**From:** ENVU Biodiversity and Land Use  
**Sent:** 17 July 2025 14:24  
**To:** Planning ContactCentre  
**Cc:** Joshua Merriman  
**Subject:** 2025/91394 at location 11, Clough Lane, Hightown, Liversedge, WF15 8AD

Please see below for ecological comments:

PROPOSED FIRST FLOOR PLAN

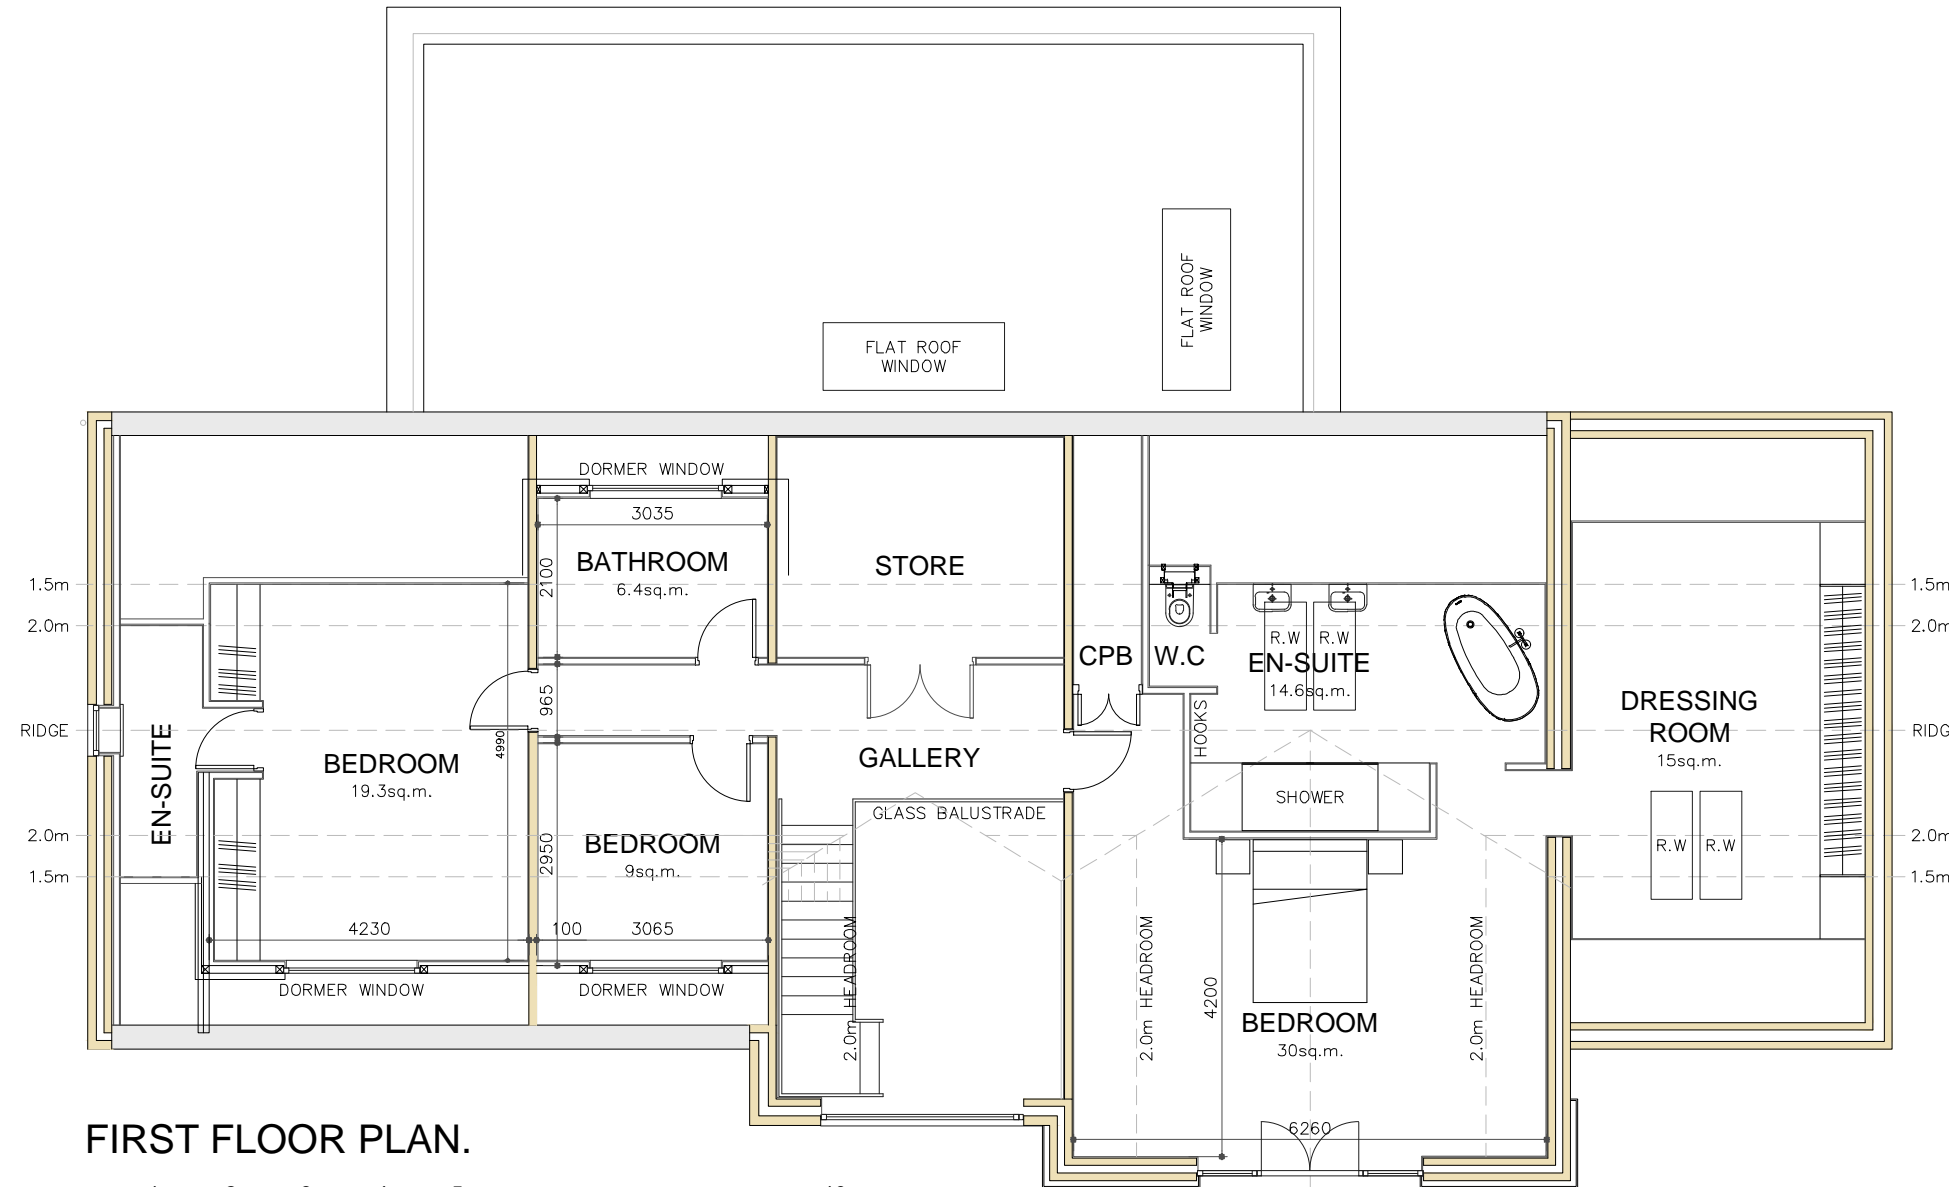
Please can it be confirmed the area (m2) of the proposed extension. This is to consider whether BNG is required. Scaled drawings will need to be provided for clarification.
